WEST SUSSEX COUNTY COUNCIL CONSULTATION

TO:	Arun District Council FAO: Mr. D. Easton
FROM:	WSCC - Highway Authority
DATE:	11 March 2022
LOCATION:	Land South of Grevatts Lane/A259 Climping
SUBJECT:	M/16/22/PL Laying out of an 18 hole 72 par golf course, a 9 hole golf course, practice greens and a driving range including a buggy compound; the formation of a new access onto the A259; construction of a club house with associated golf club facilities; the construction of a maintenance building and external area of hardstanding; the laying of parking, new roads and paths; new landscape planting; surface water drainage basins and water storage reservoirs; and other earth works and infrastructure. This application also lies within the parishes of Climping and Yapton, is a Departure from the Development Plan and affects a Public Right of Way. This application is subject to an Environmental Statement.
DATE OF SITE VISIT:	5 March 2022
RECOMMENDATION:	More Information Required

This is the first WSCC County Highways (CHA) response to a planning application for the laying out of an 18 hole 72 par golf course, a 9 hole golf course, practice greens and a driving range including a buggy compound;

Figure 8: Illustrative Golf Plan (Source: Client)

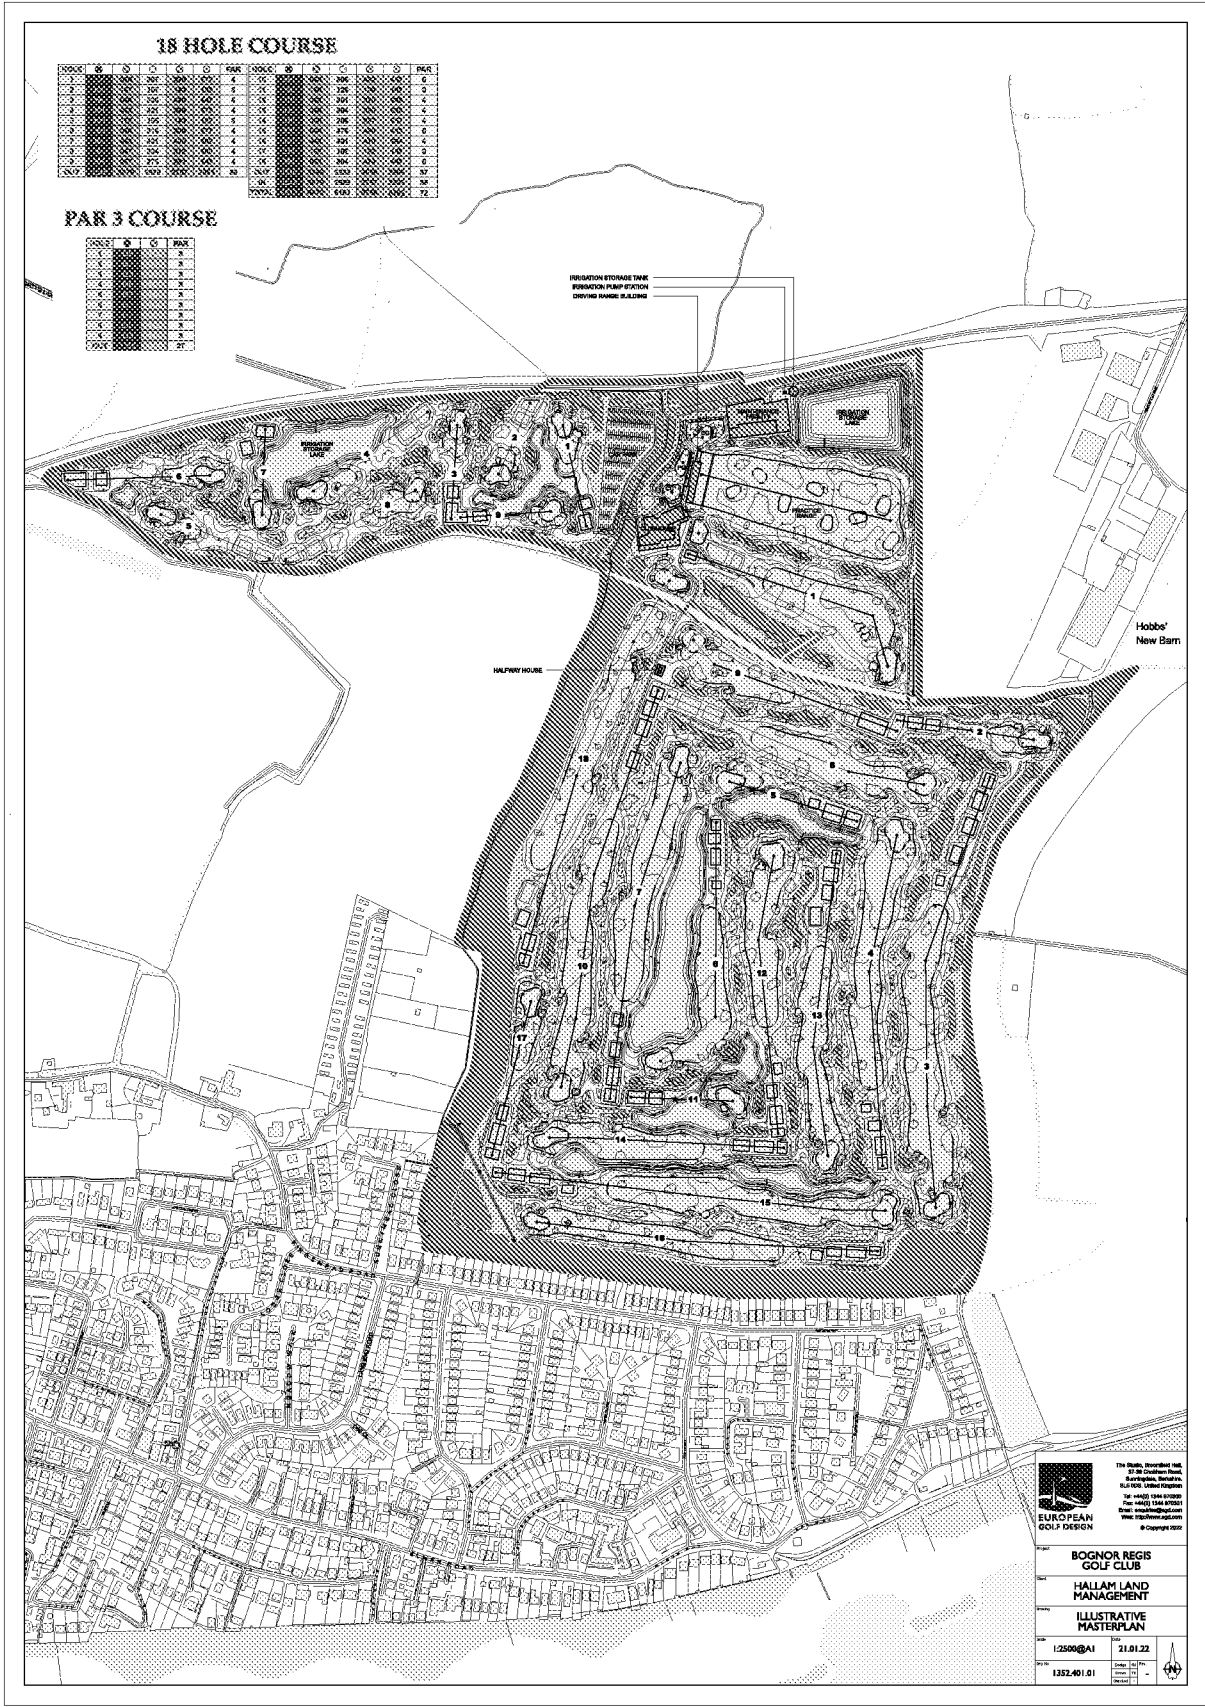
From scrutiny of the submitted drawings, some of the fairways appear to require users to tee-off towards the A259. The applicant should provide details of how the public highway would be protected from stray balls being pitched towards it.
